**WEST SUSSEX COUNTY COUNCIL
STRATEGIC PLANNING CONSULTATION**

SUBJECT: M/85/15/PD- Application for prior approval under Class M for change of use from solicitors office (use class A2) to dwellinghouse (Use Class C3)

1 Middleton Court, Elmer Road, Middleton, West Sussex

SITE PLAN 1:500@ A4

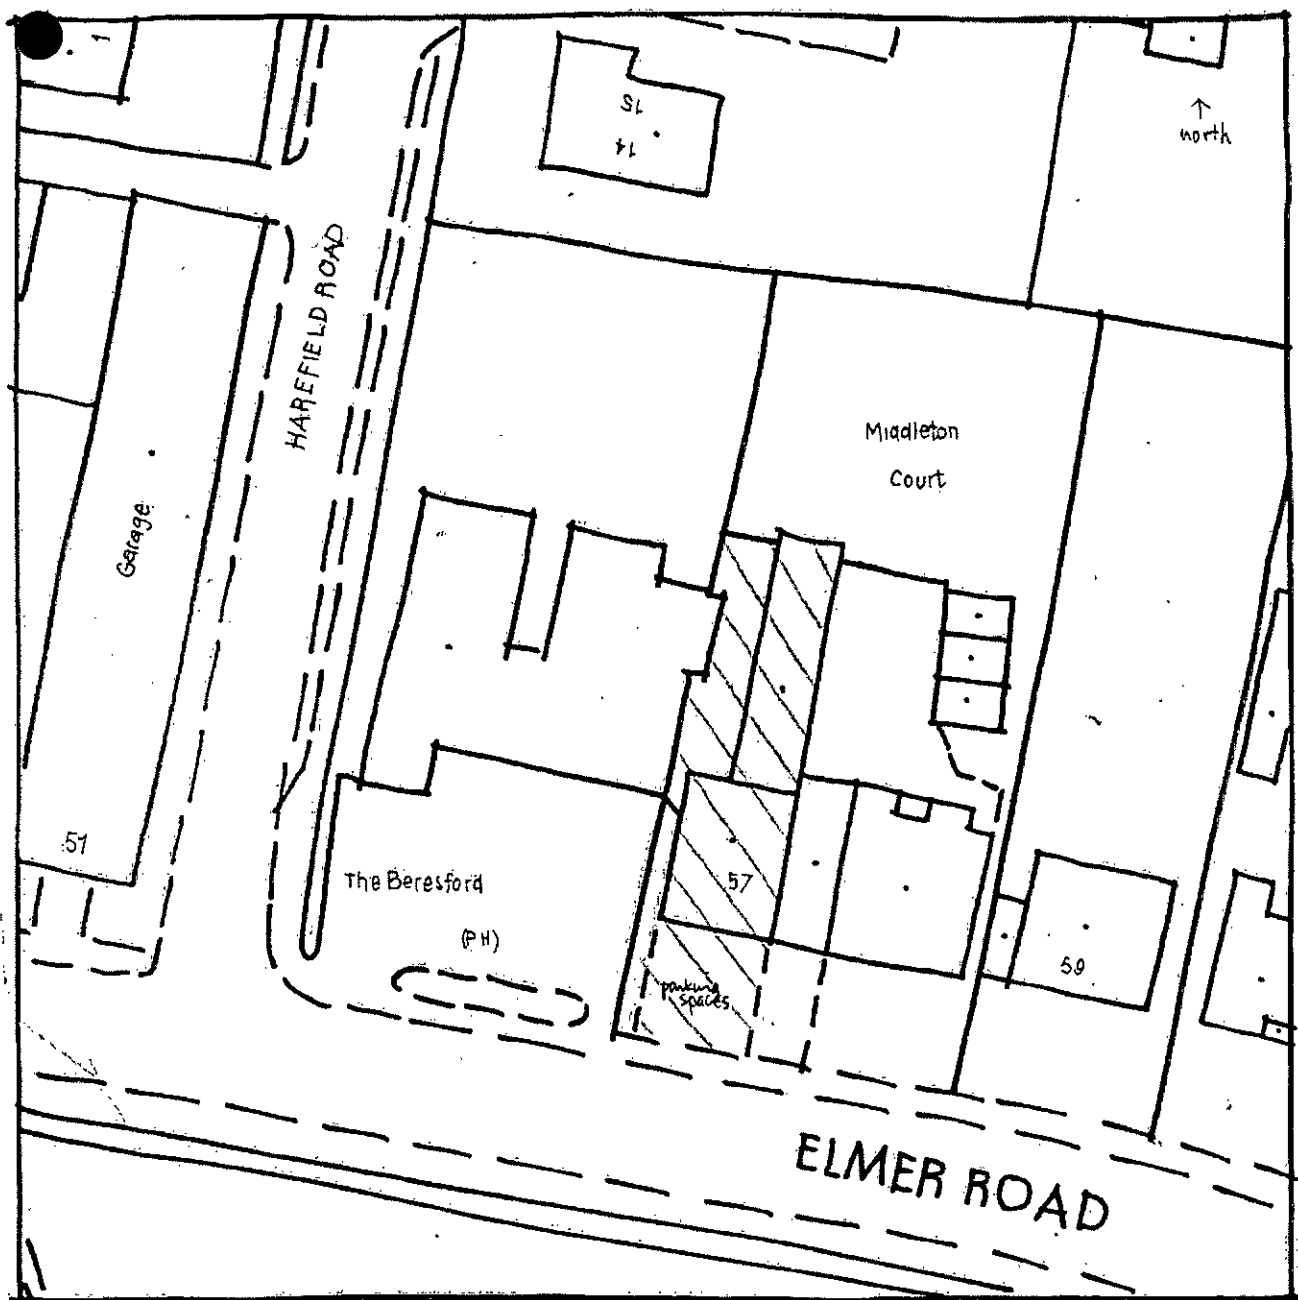
The existing parking area for the offices is included within the red edging. The prior notification process does not enable parking provision or other matters relating to accessibility to be considered. Nevertheless, it would appear that some parking is to be retained for the residential use.
